City of Mercer Island
Department of Community Development
Building and Land Use Planning Review

RE: Permit # 2203-002 - owner driven revisions
For proposed development at 4045 W Mercer Way
Parcel #: 362350-0395

This letter is to provide a brief synopsis of the property-owner driven changes to the building permit submission #2203-002 at 4045 W Mercer Way as instructed by Gareth Reece. The changes include the following:

A3.0

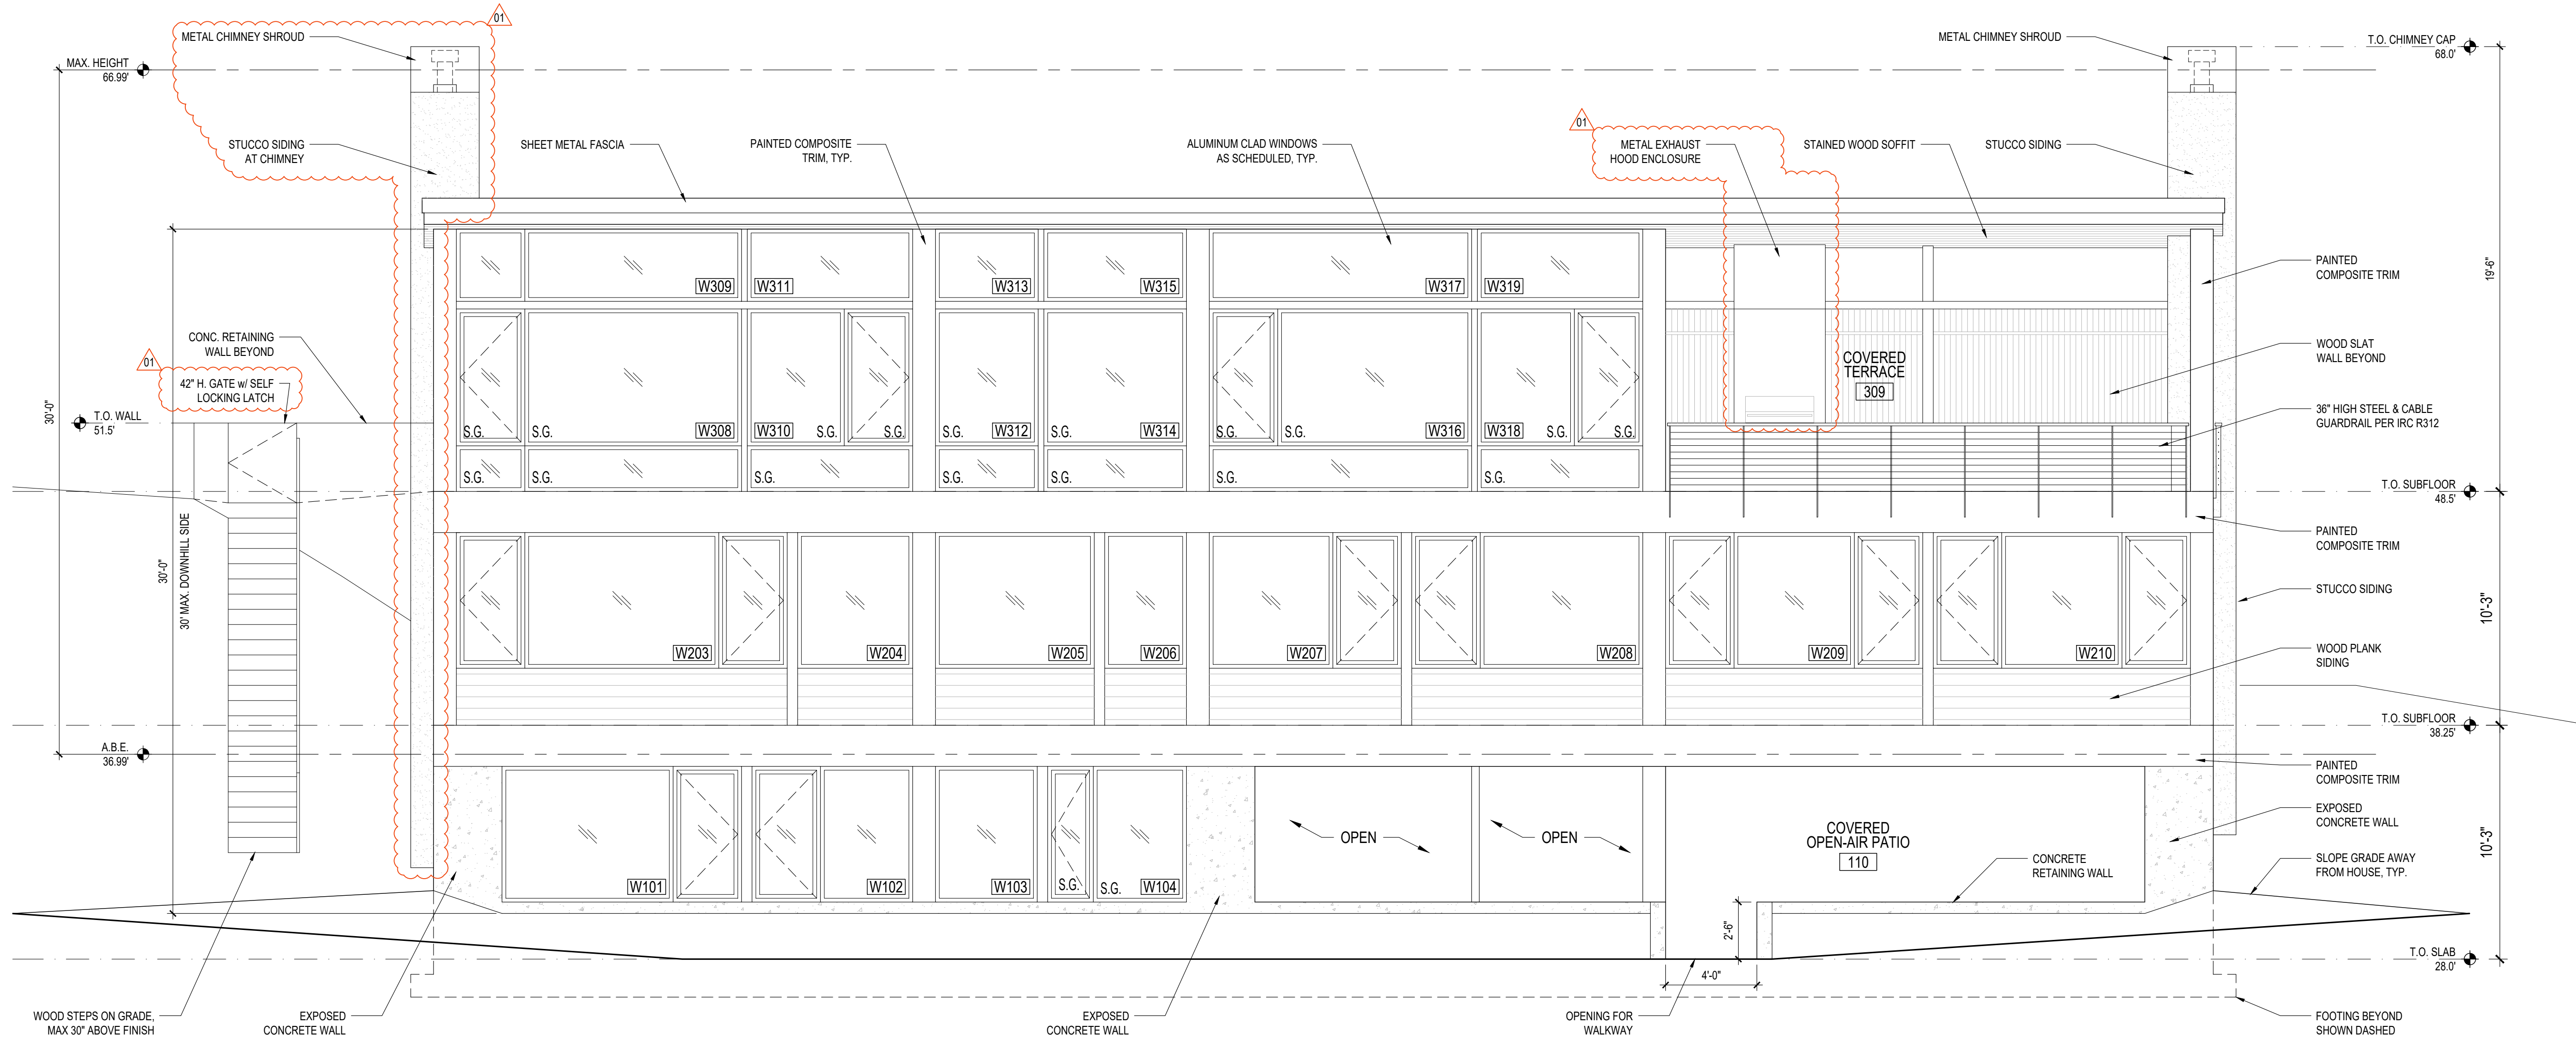
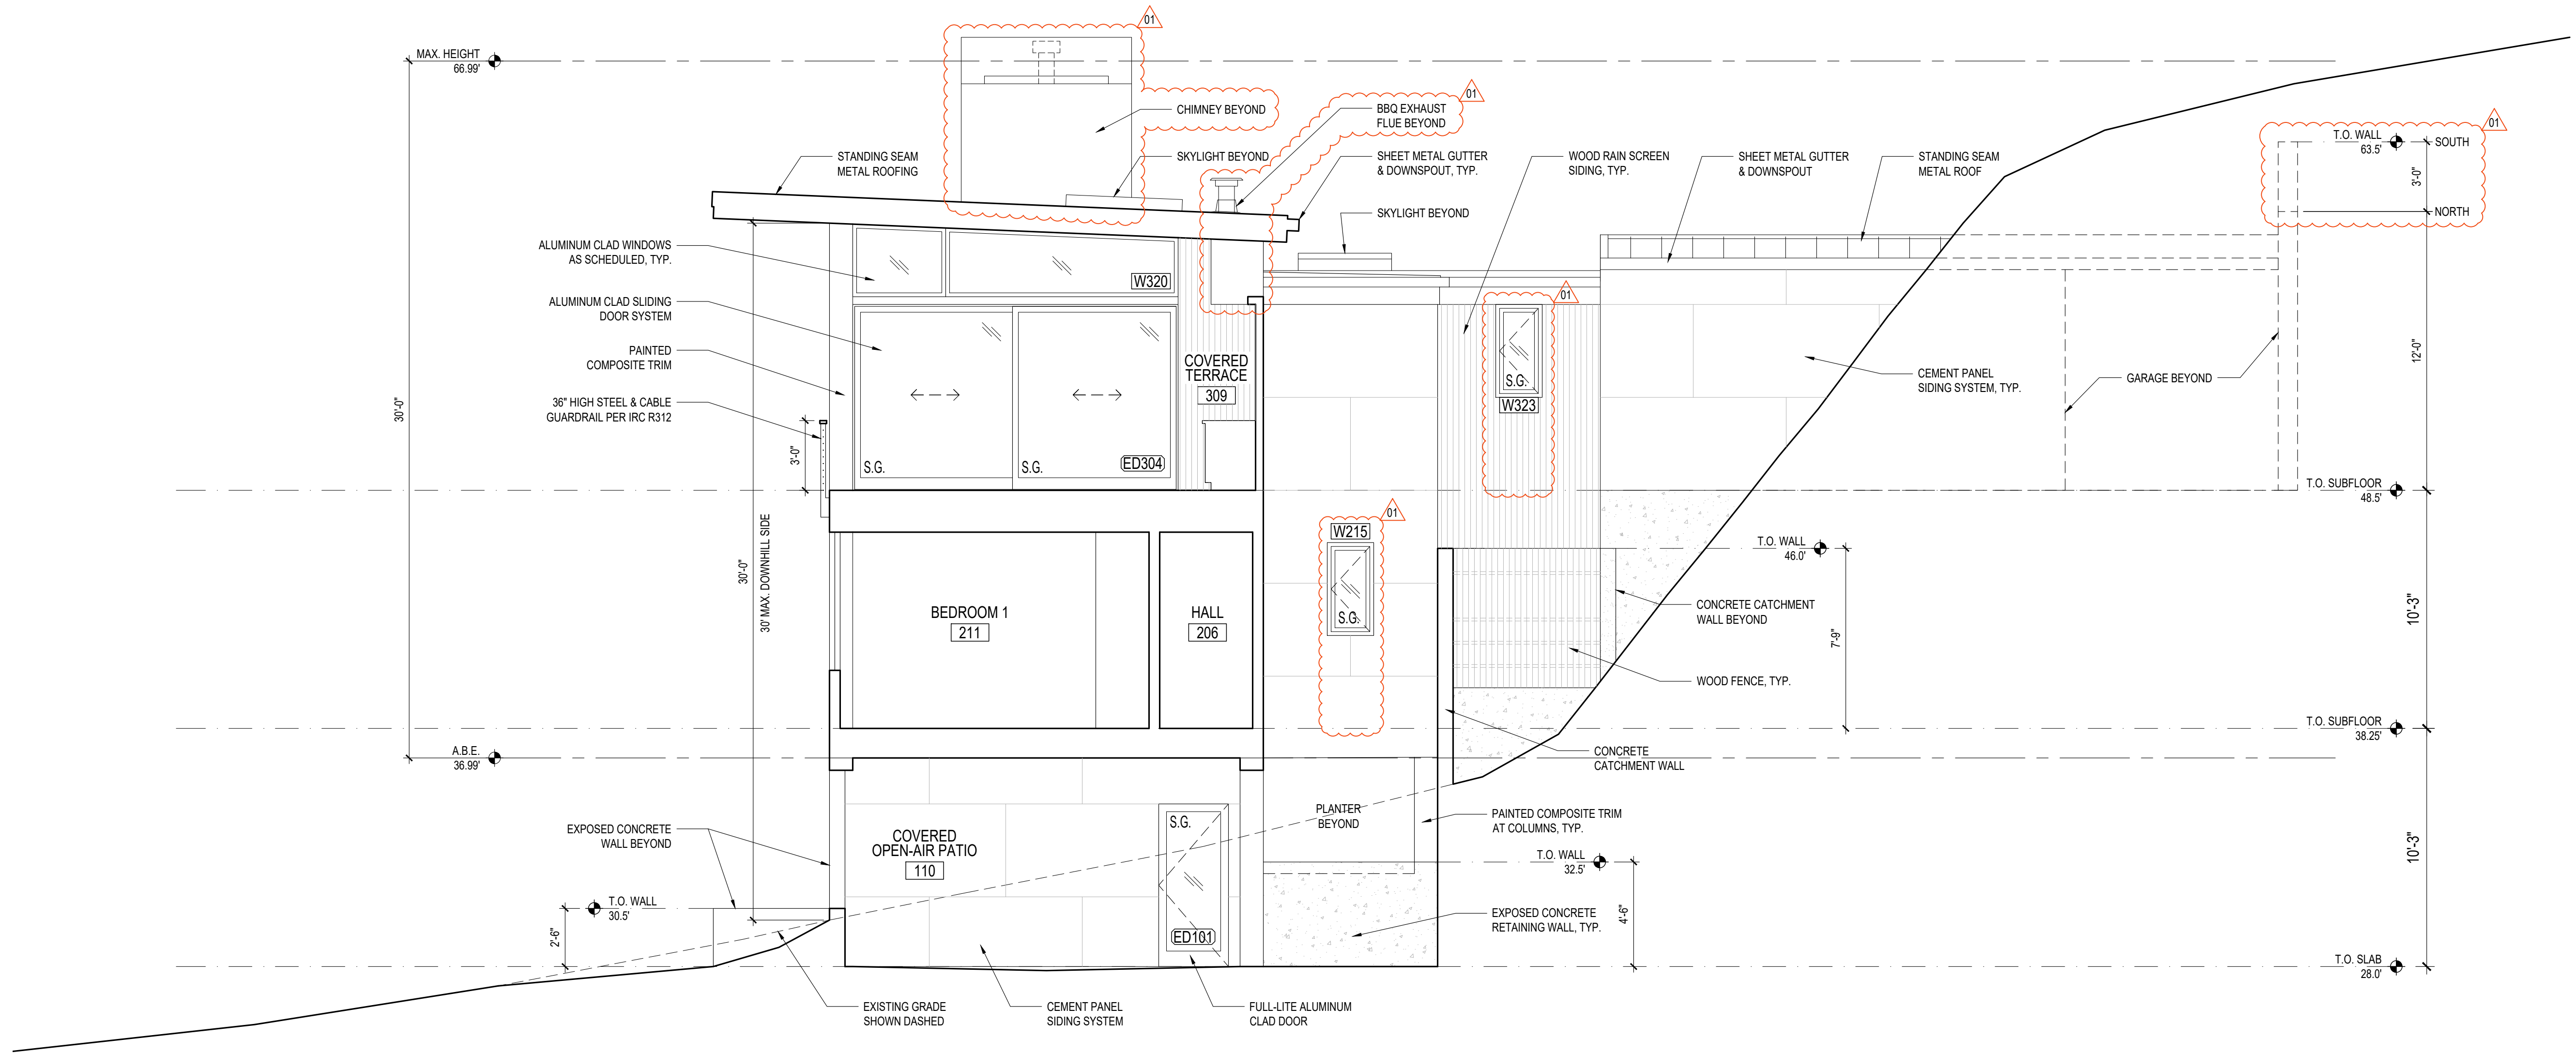
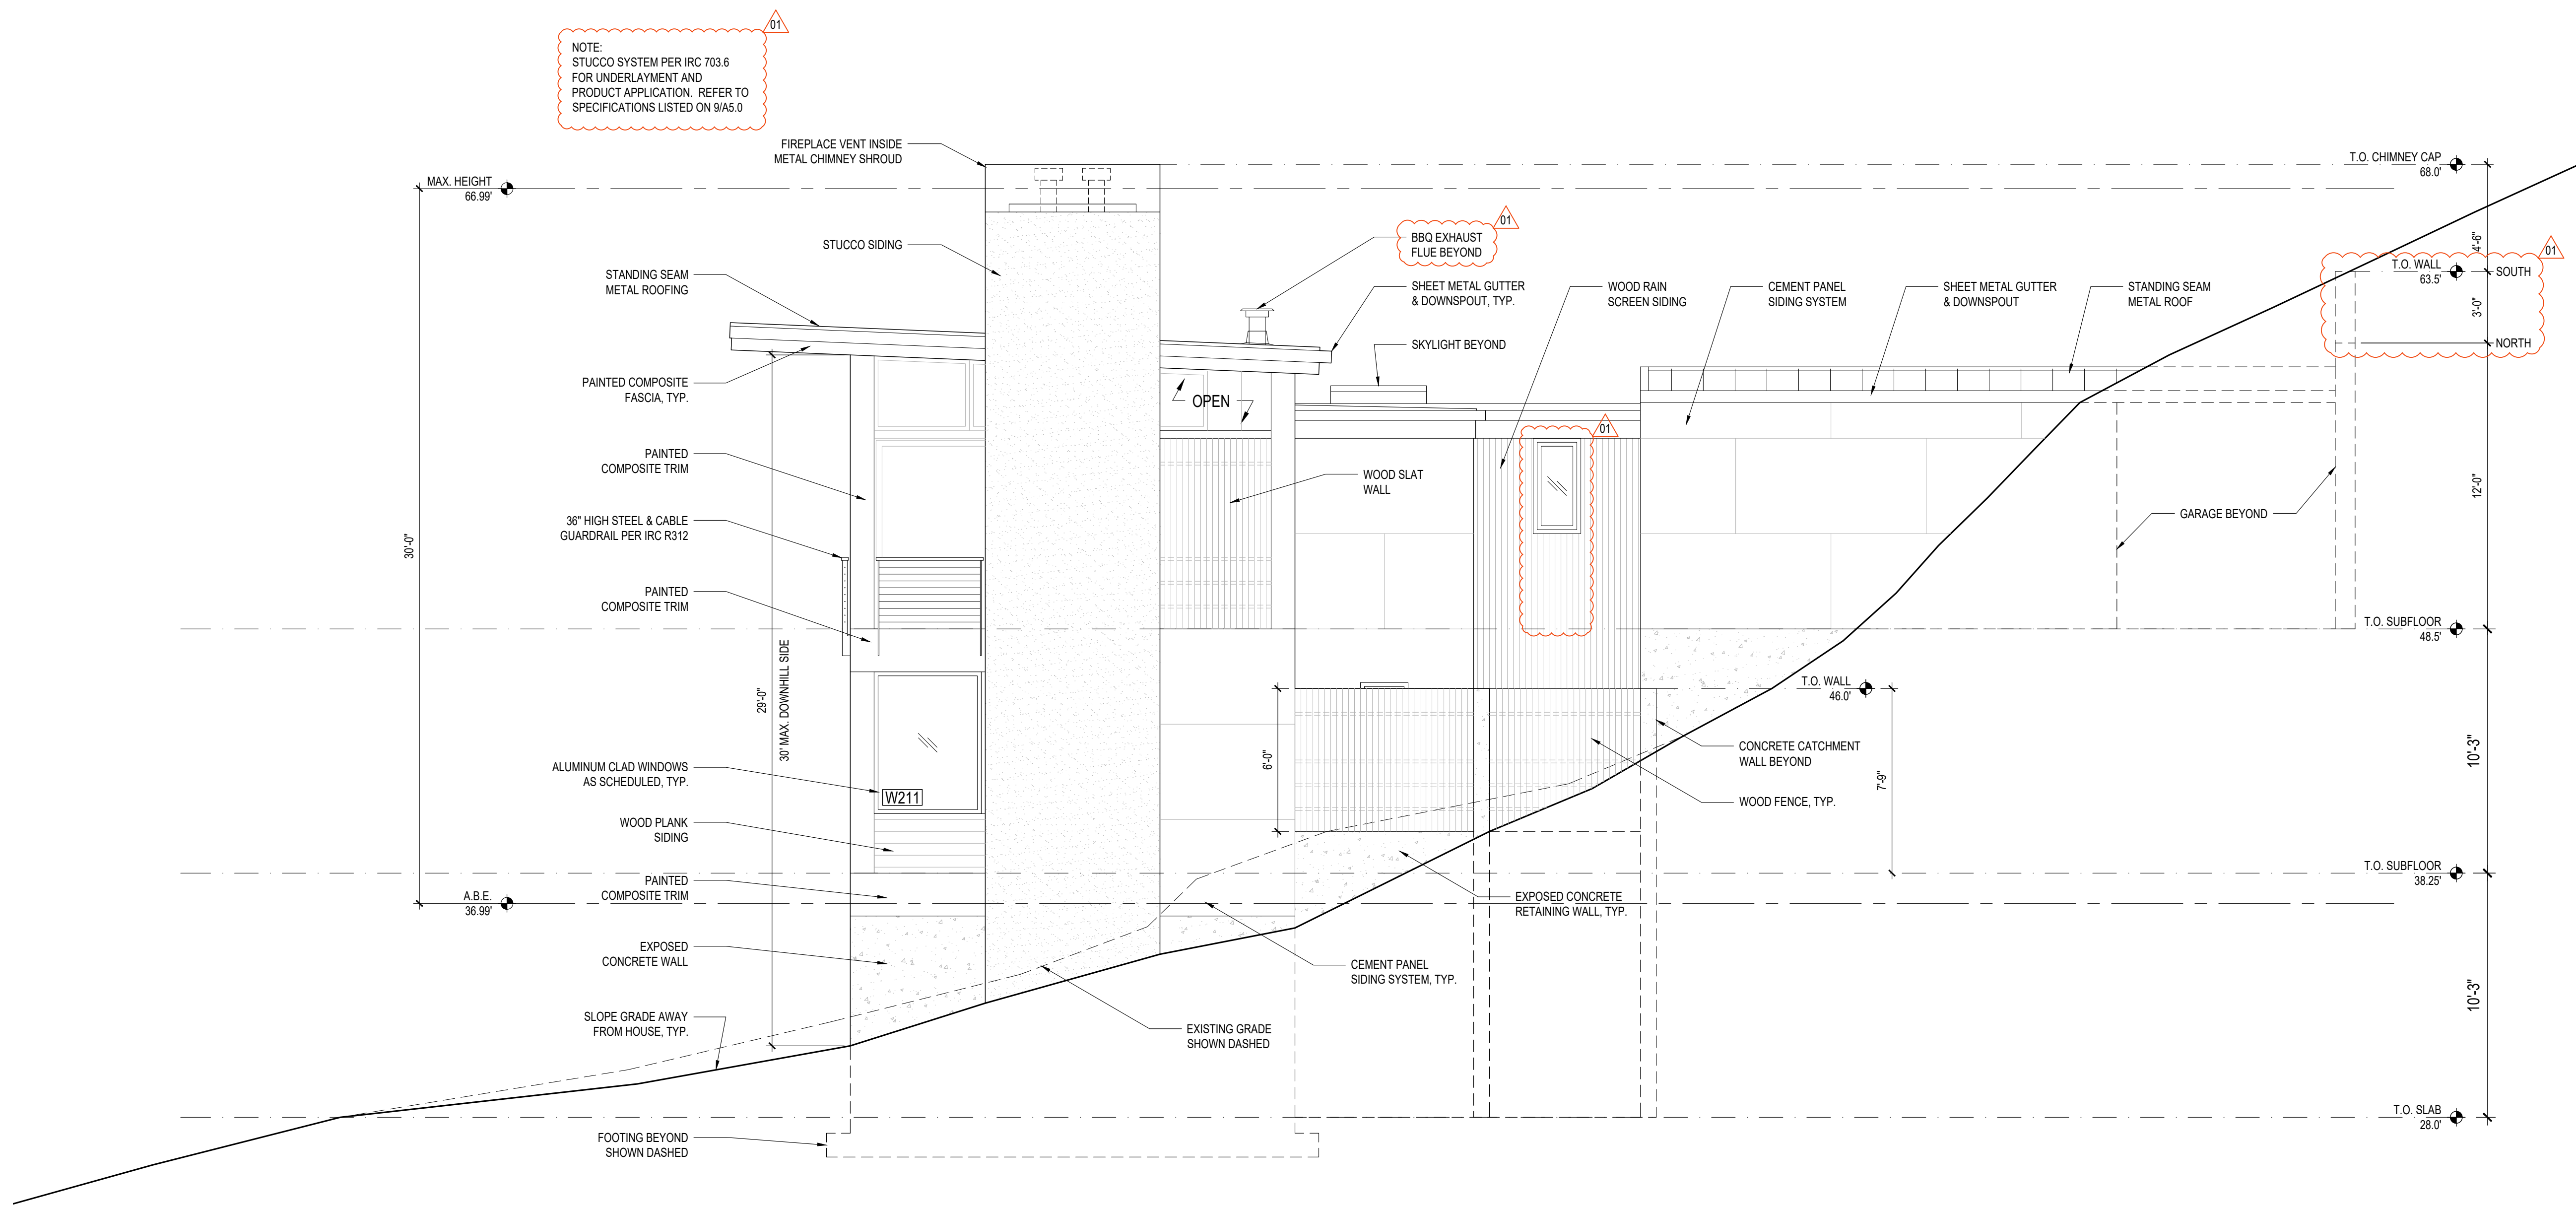
- 1) Revised fireplace location at the north end of the Living Room on the Upper Level Plan.
 - a) A traditional, gas fireplace with a chimney is proposed.
 - b) The plans, elevations and building sections have been updated and clouded.
 - c) The zoning code calculations for lot coverage and gross floor area have been updated and clouded.
- 2) A few windows have revised opening sizes or revised operability on the back side of the home.
 - a) The exterior elevations and opening schedule have been updated and clouded
